Ribble Valley Borough Council

App no: 3.2026.0350

Address: Land South of Accrington Road Whalley

Proposal: Approval of details reserved by conditions 6 (site access and off-site works of highway mitigation) and 11 (detailed specifications for the construction of the car park) of planning permission 3/2022/1158.

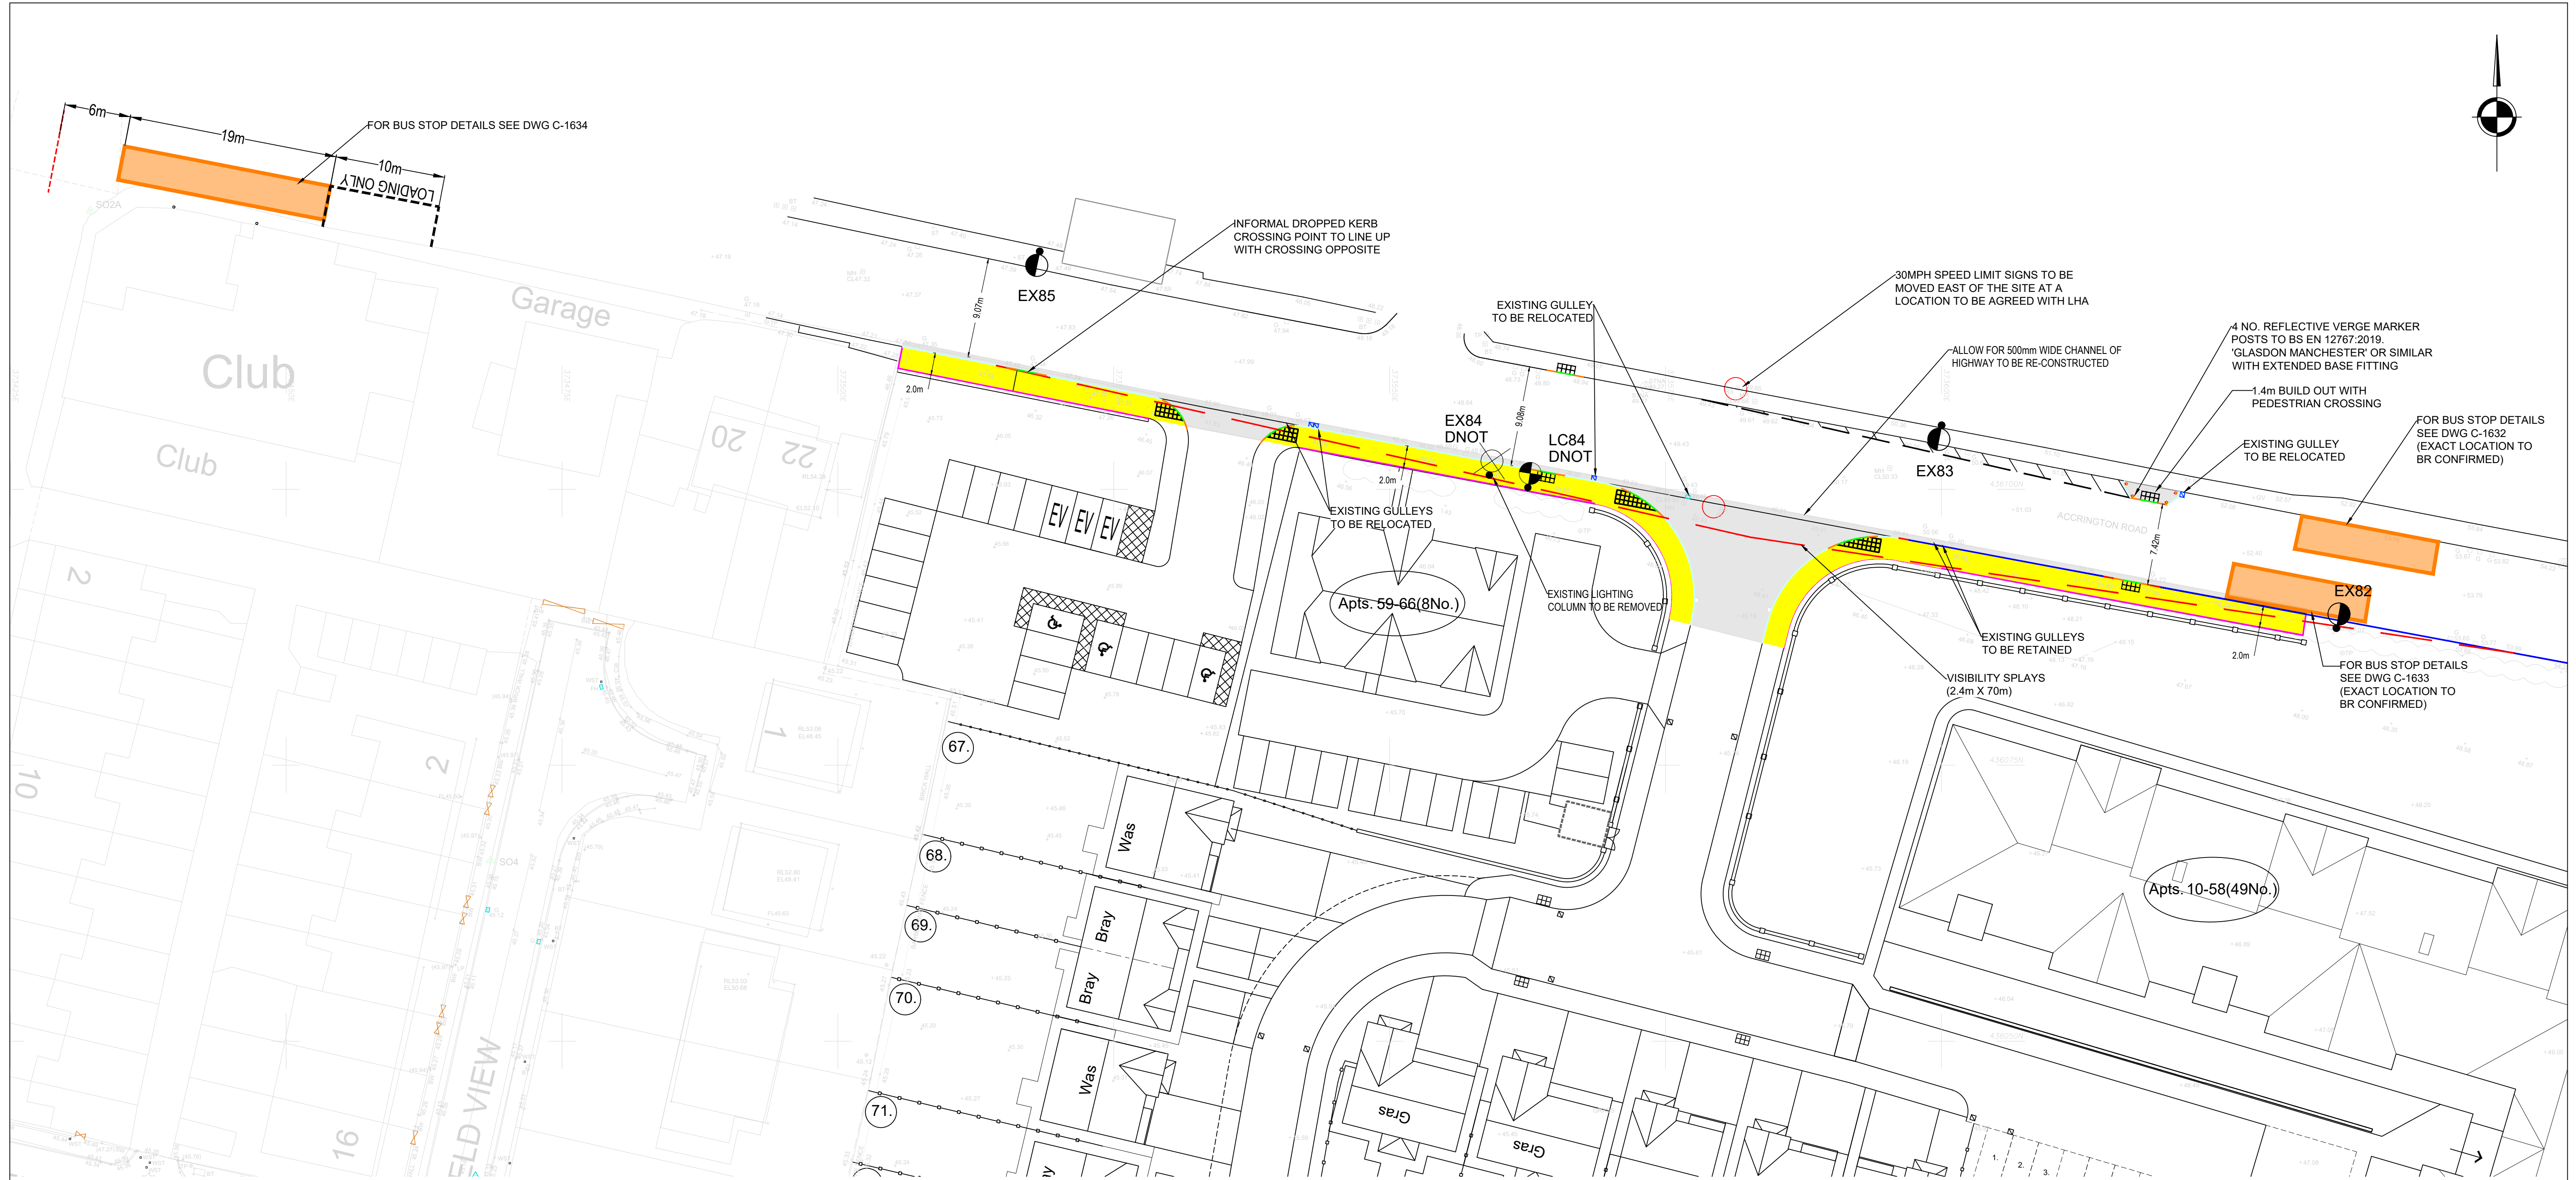
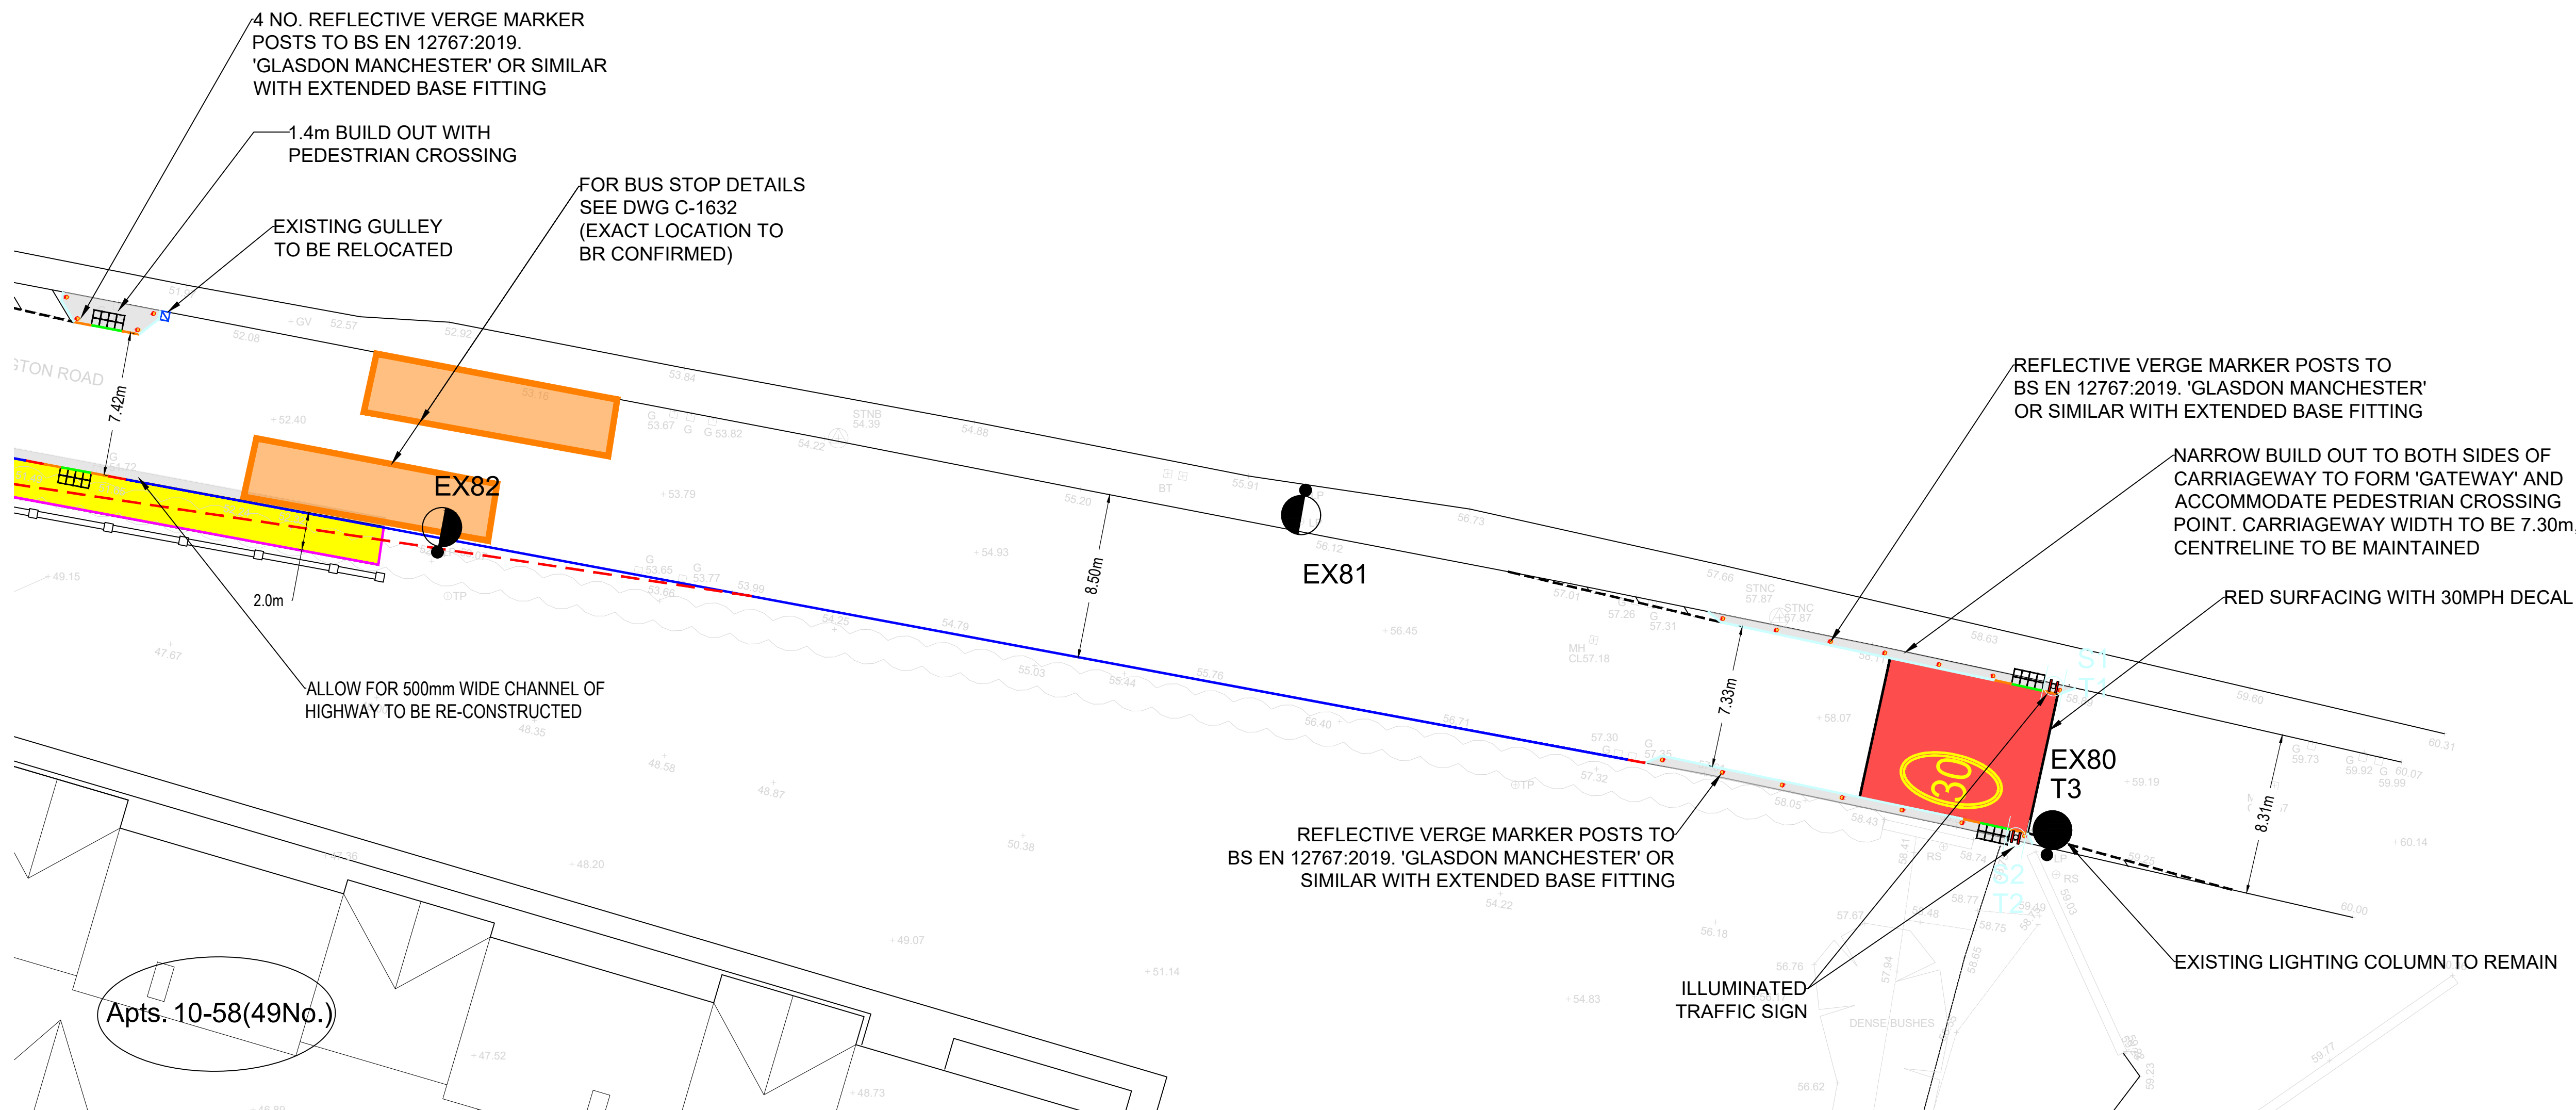
There is one element missing from the scheme of works:- *Uncontrolled pedestrian crossing to the west of the Public Car Park junction which will connect to the existing dropped kerb provided where the existing eastbound bus stop is located.*

TITLE: S278 LAND PLAN

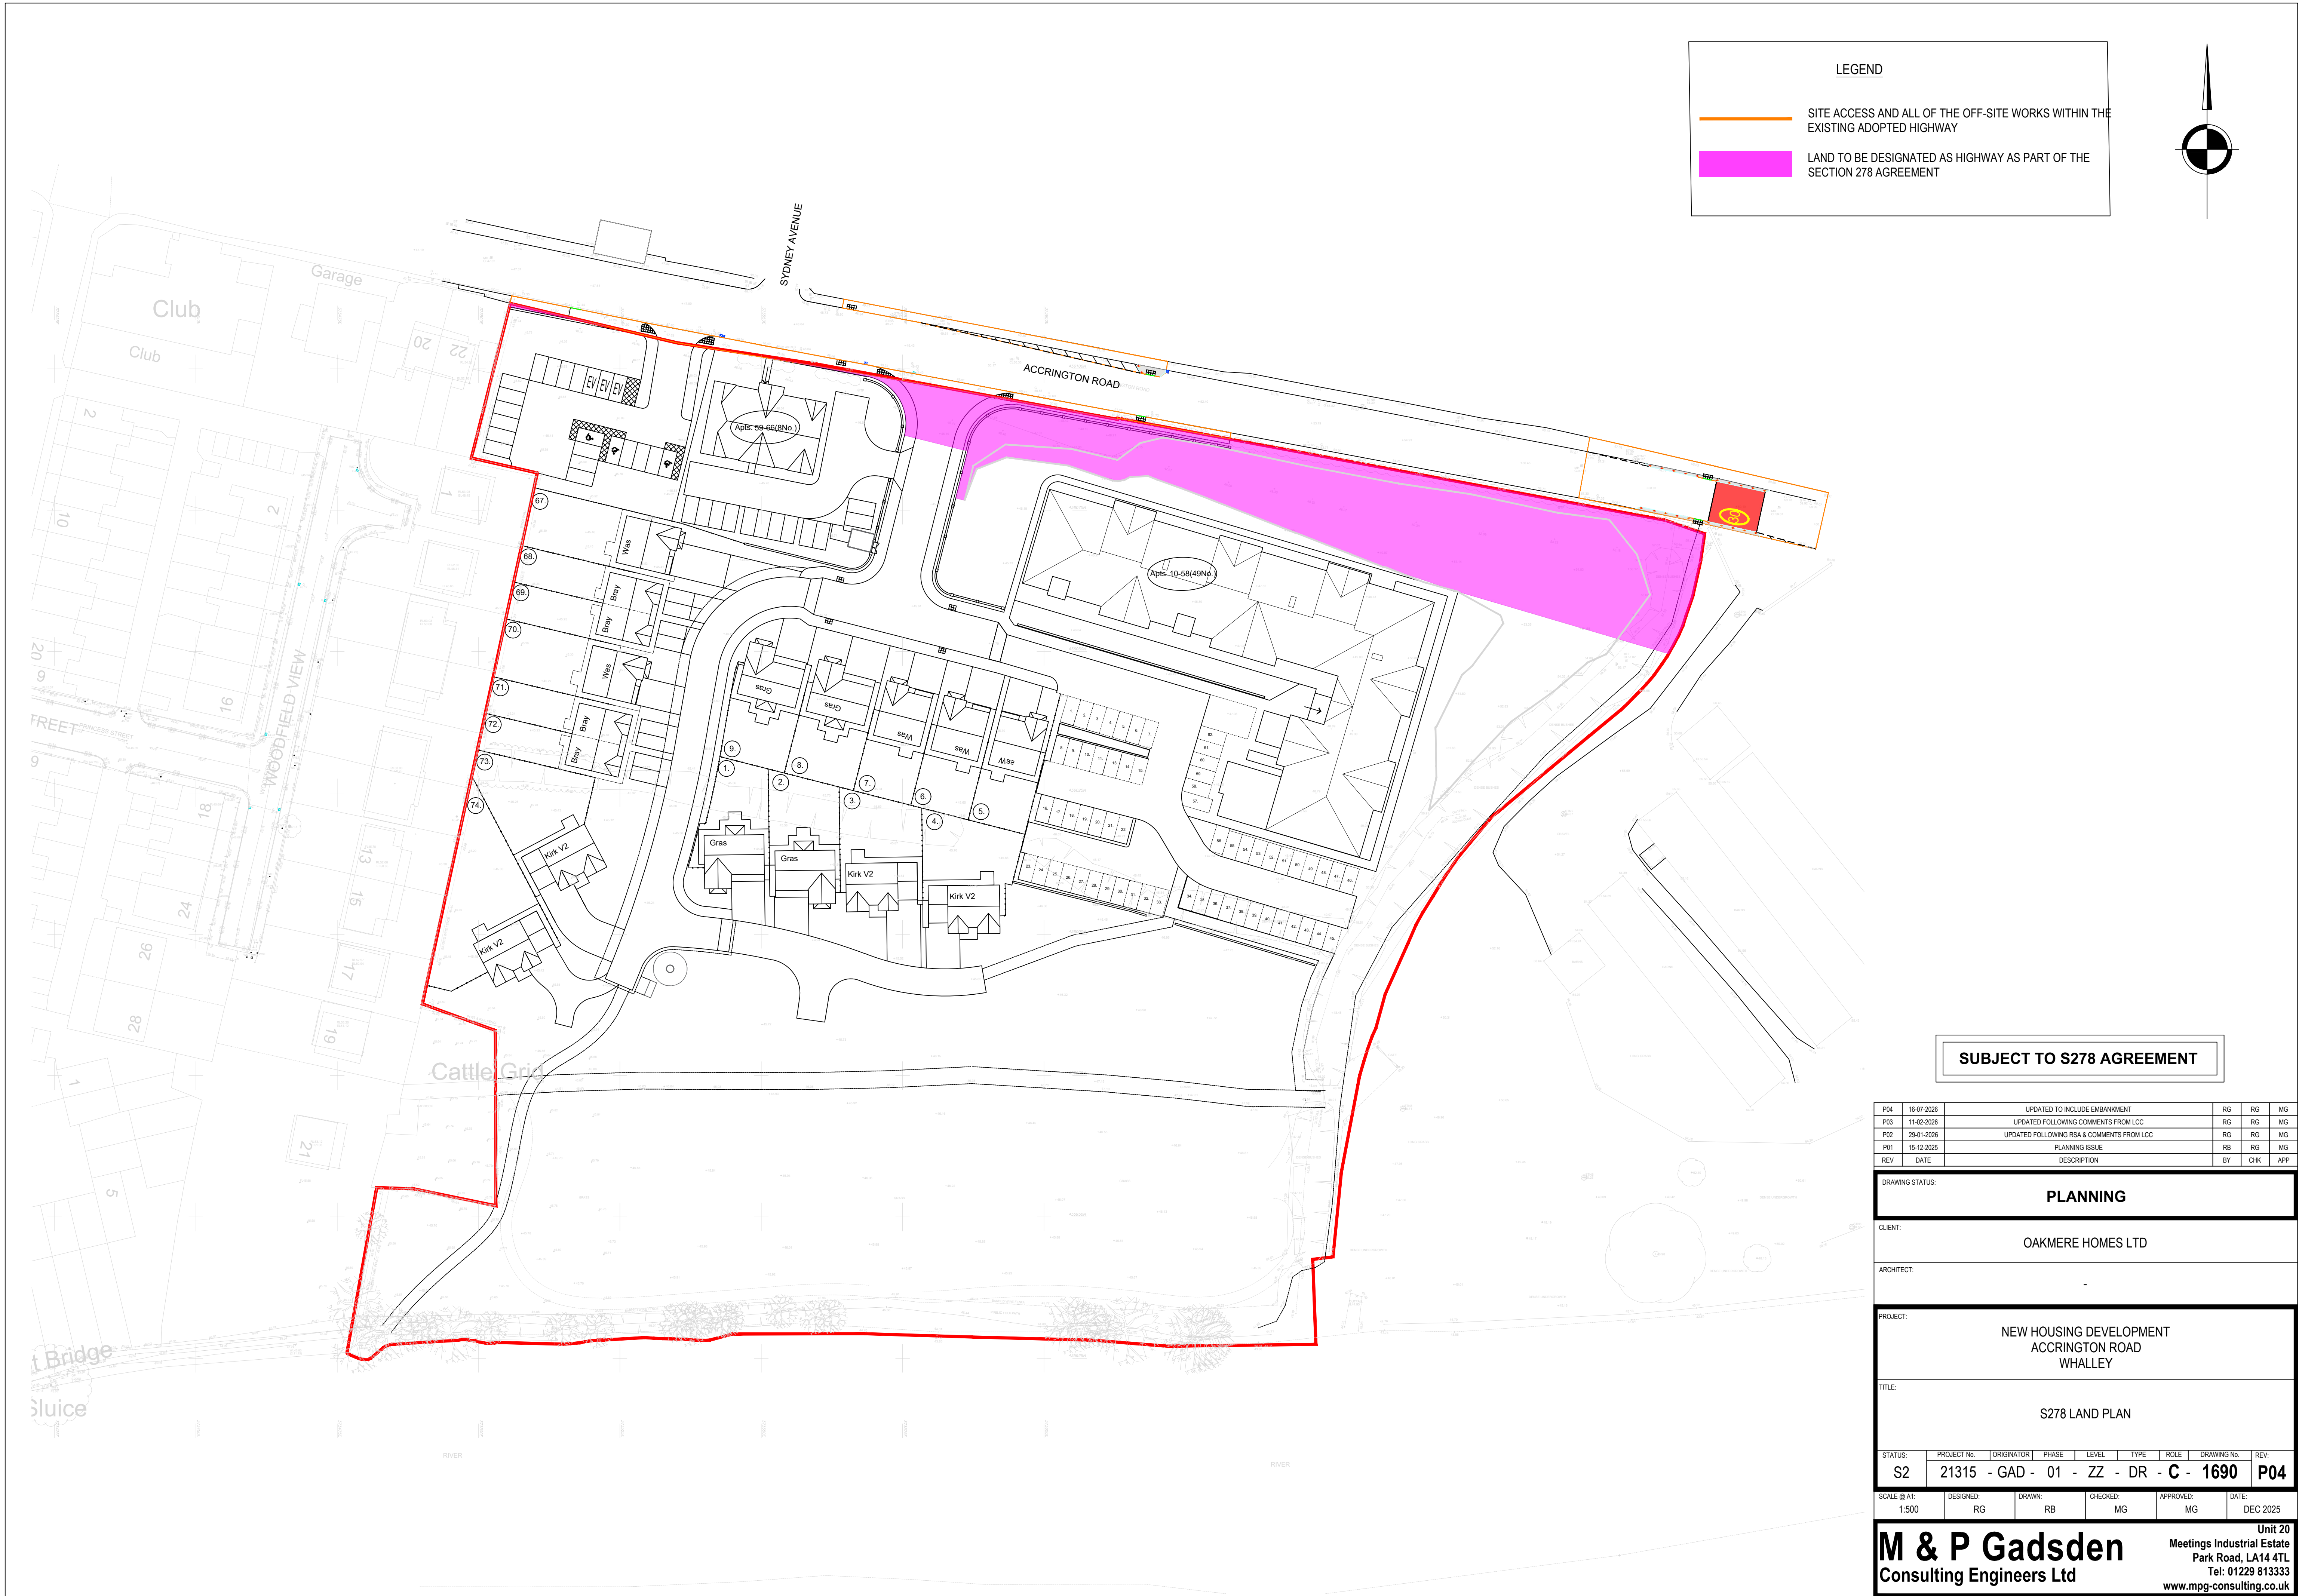
There is also discussion progressing regarding the embankment supporting the highway which is yet to be resolved.
